**Werris Creek Coal Mine – Modification 2 (10_0059 MOD 2)
Review of Environmental Assessment**

NSW Trade & Investment, Regional Infrastructure & Services, Division of Resources & Energy (DRE) has reviewed the *Environmental Assessment for the Werris Creek Coal Modification 2 (PA 10_0059)* (EA) dated April 2015 and provides the following comments which are directed at specific areas of DRE responsibility for this proposal.

Figure 1: Conceptual Final Landform

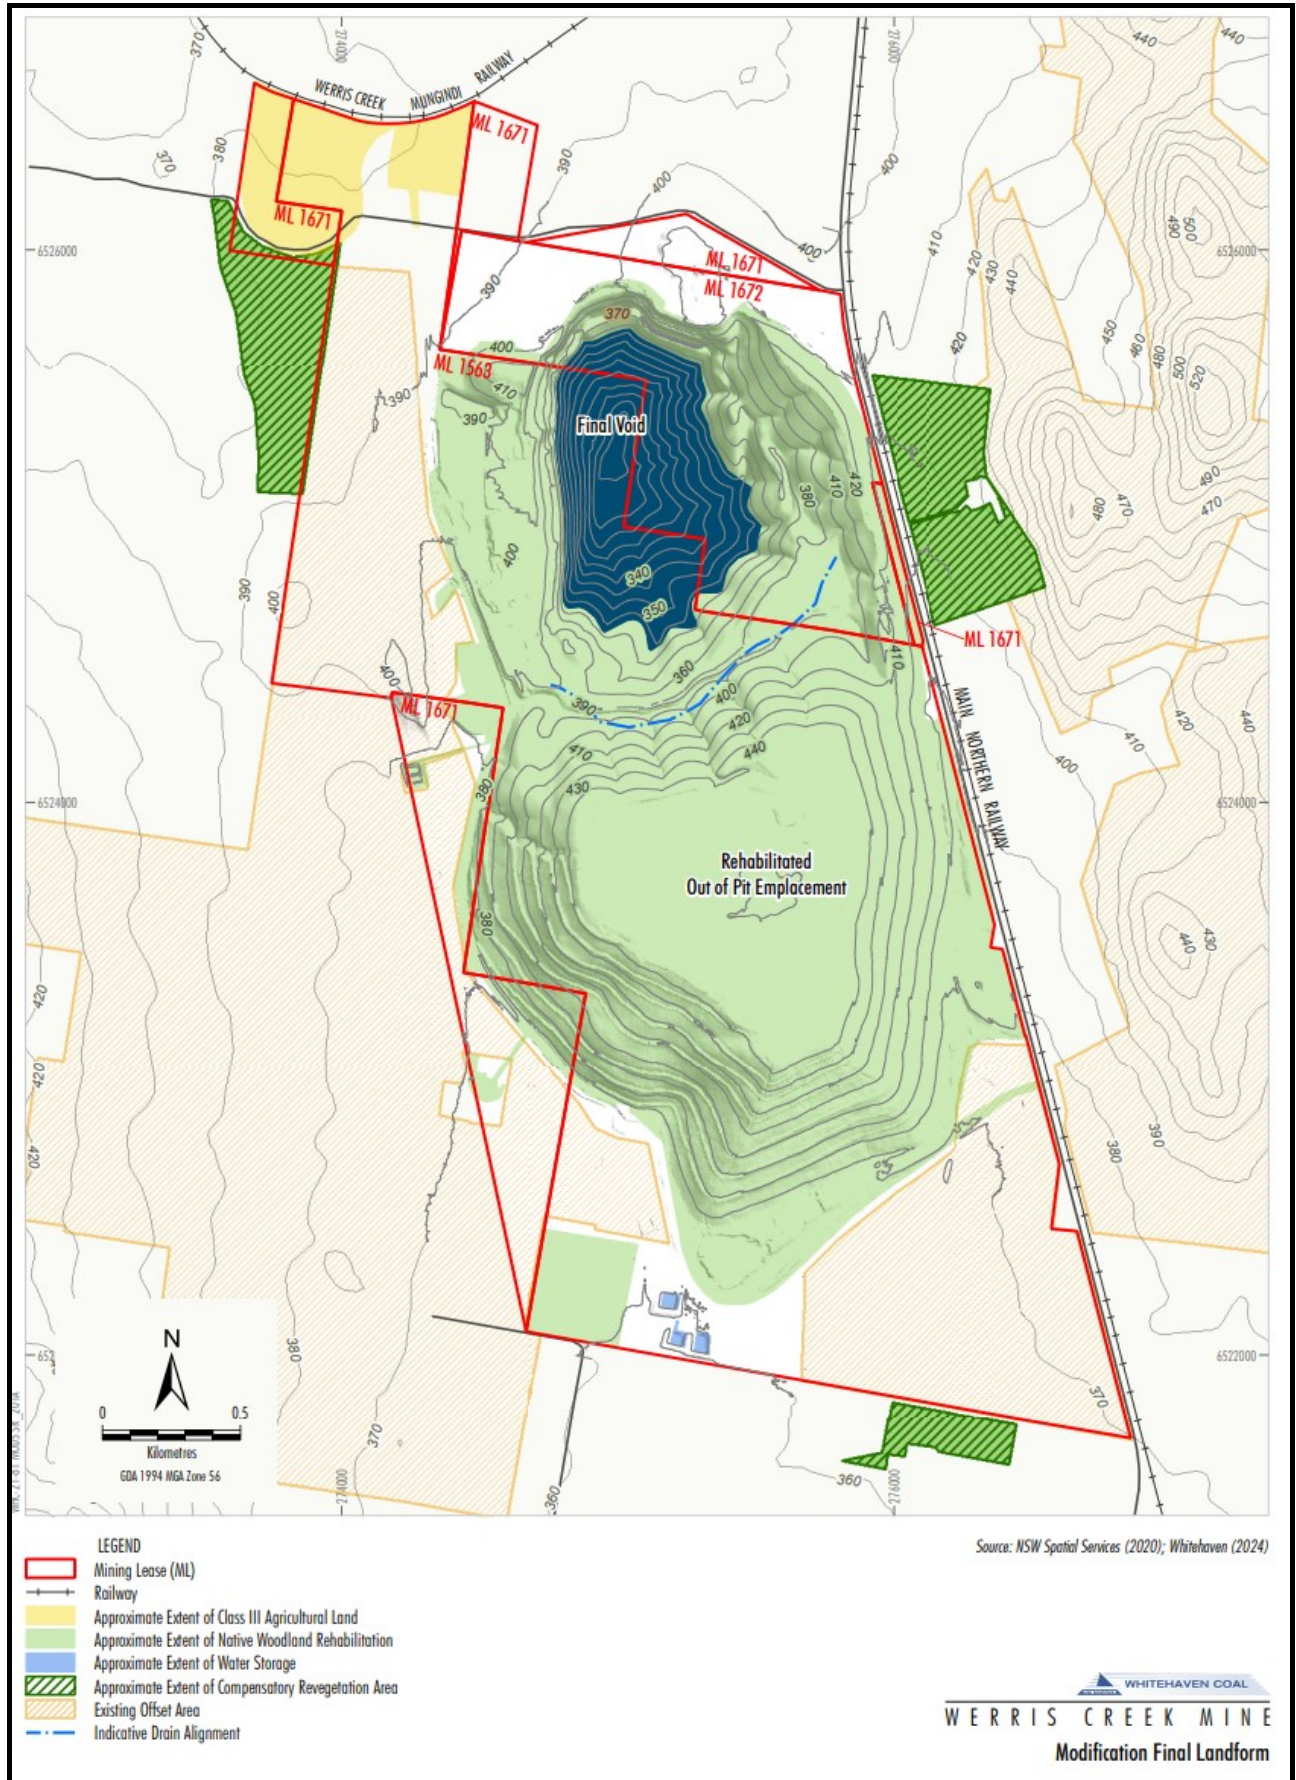
DRE considers the proposed modification will result in a final landform formation that is not consistent with current rehabilitation objectives, as table tops are not sympathetic with local topography. However, DRE notes the Proponent's statement in the EA that to construct a more distinct "hill top" would require an increase in overburden emplacement height which would contradict commitments made in the 2010 EA for the Werris Creek Mine (RWC, 2010) and on which the current consent was granted. DRE expect the design of the final landform formation could be improved as part of the development of the MOP.

- The applicant should, if the application is successful, provide DRE with a new Mining Operations Plan (MOP) which addresses the modified consent elements;
- The MOP should provide detail on the proposed 'minor rises and swales' referenced in Section 2.10.4 of the EA and undulating landform profiles referred to within Section 2.10.6.3; and
- A Rehabilitation Cost Estimate (RCE) should accompany the new MOP application. The tool to prepare the RCE ('ESB26 Rehabilitation Cost Calculation Tool') is available on the DRE website at <http://www.resourcesandenergy.nsw.gov.au/miners-and-explorers/rules-and-forms/pgf>.
